AB/25/26/L

Address: 19A High Street Arundel BN18 9AD

Proposal: Listed building consent to repair and strengthen existing roof structure and reinstate tiled roof.

Drawing Title:
EXISTING AND PROPOSED ROOF PLAN
(NO CHANGES)

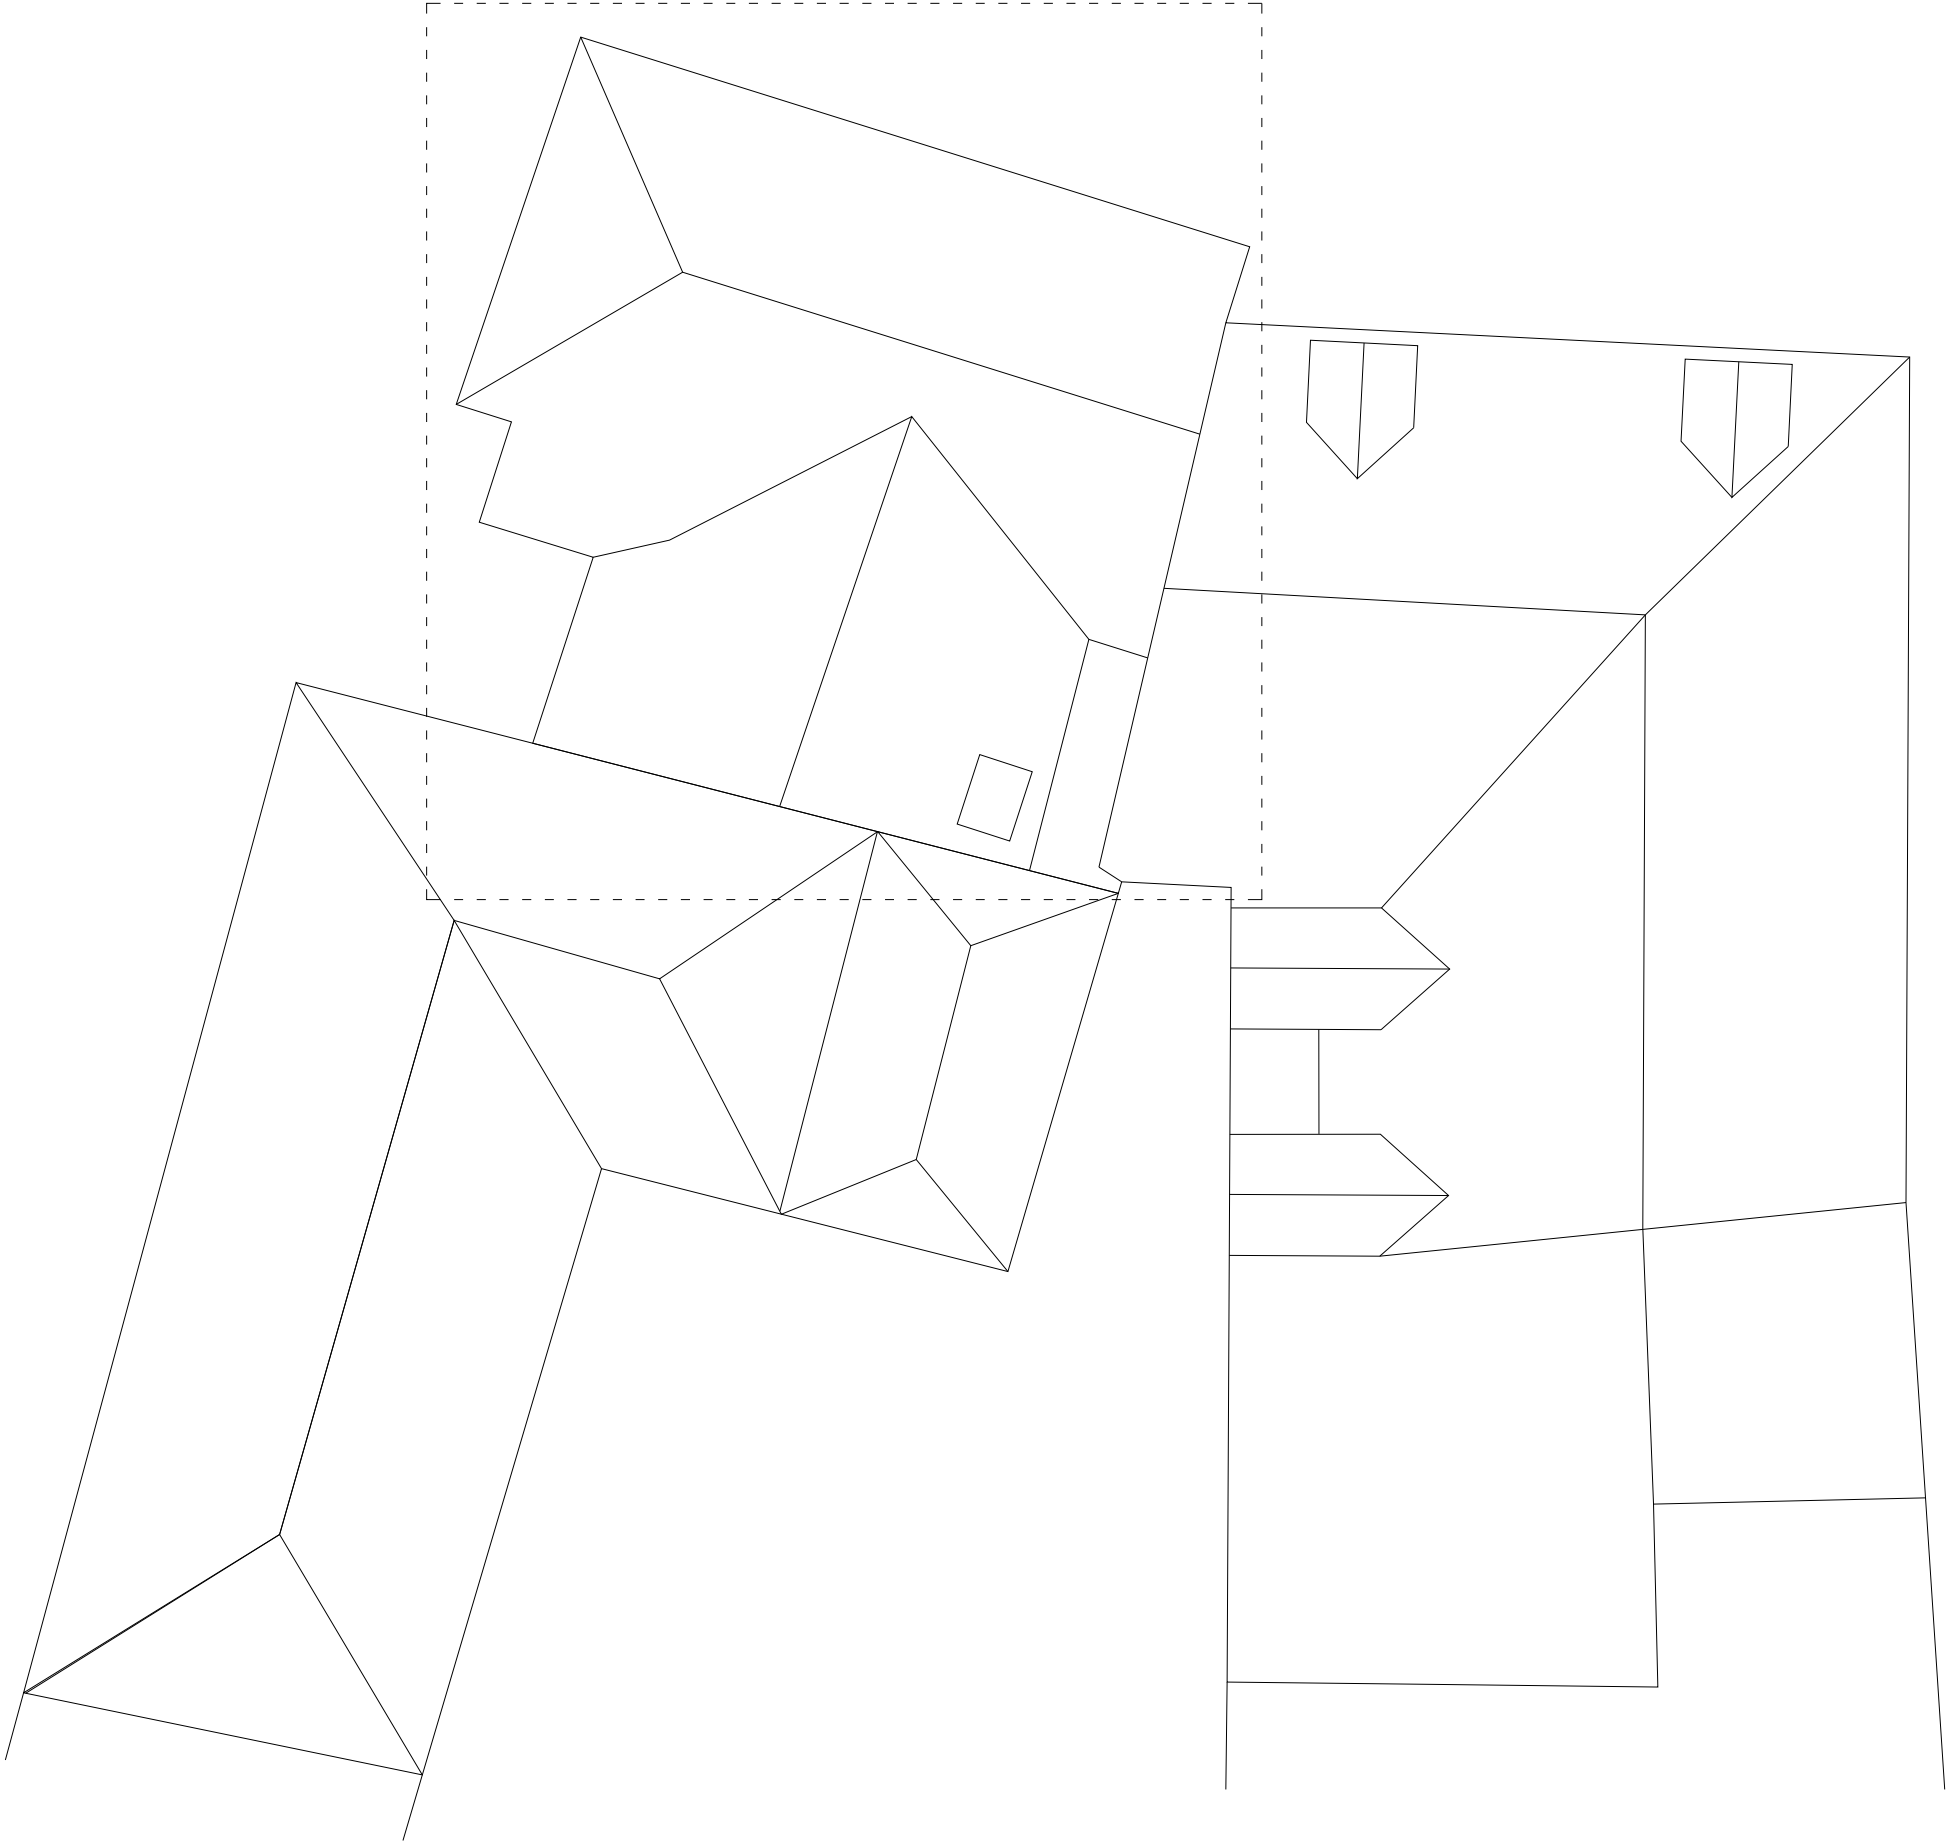
I have met the builder and agent at the property, and it is clear that the works are required in order to maintain the roof space. The proposed works will follow a conservation-led approach, which is positive. This approach prioritises repair over replacement though the use of metal braces or straps which will ensure that the historic fabric is retained. Where the fabric is so deteriorated it is positive to note that any replacement material will match the existing ones in terms of species, dimensions, section, profile and any detailing. This will help to ensure that the significance of the roof space is maintained.

It is assumed that the existing tiles will be re-used when the works are completed.
